Chen Harvey

Response to Mercer Island comments letter

ARBORIST TREE PLAN

ARBORISTS SITE PLAN
 1" = 10'-0"

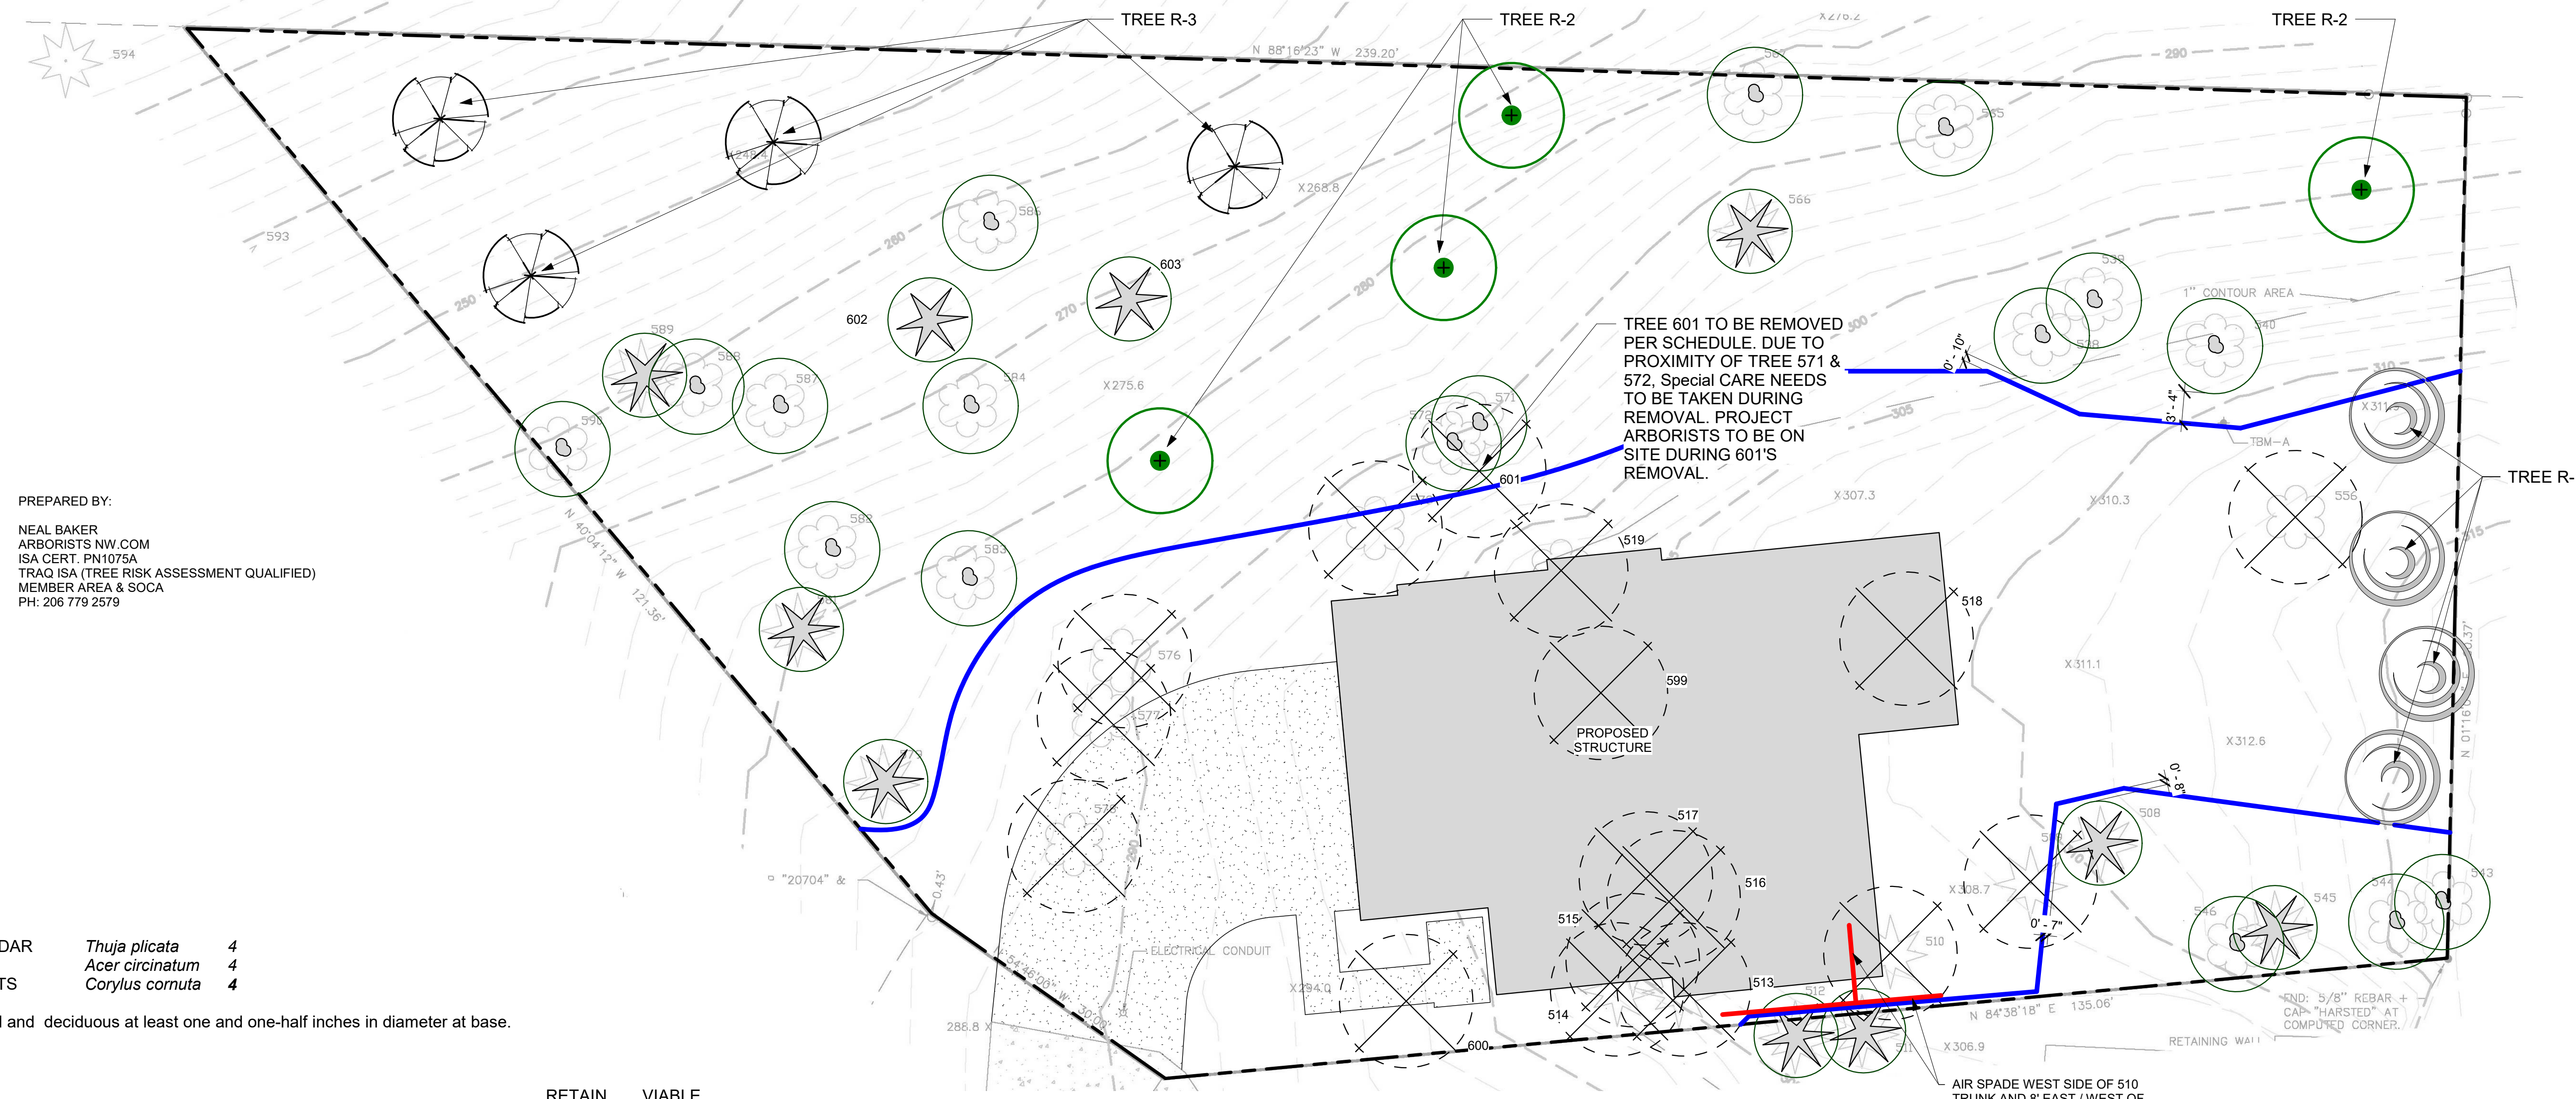
The tree protection fencing has been adjusted out to 40' for tree 508. The dripline is artificially wider than normal due to damaged treetop. Tree 579 has had its dripline rescaled to the correct size

Replanting plan: has been updated to include 55 trees.

Regarding the determination of critical root zones: The tree protection fencing is located outside of the driplines of all retained trees and is mapped as such. Given as there are large swaths of trees on the West and north side of the proposed construction individual limits of disturbance are not included and would be redundant. Again, Limits of Disturbance on trees directly adjacent construction are located outside their driplines, this covers any tree behind those adjacent as well.
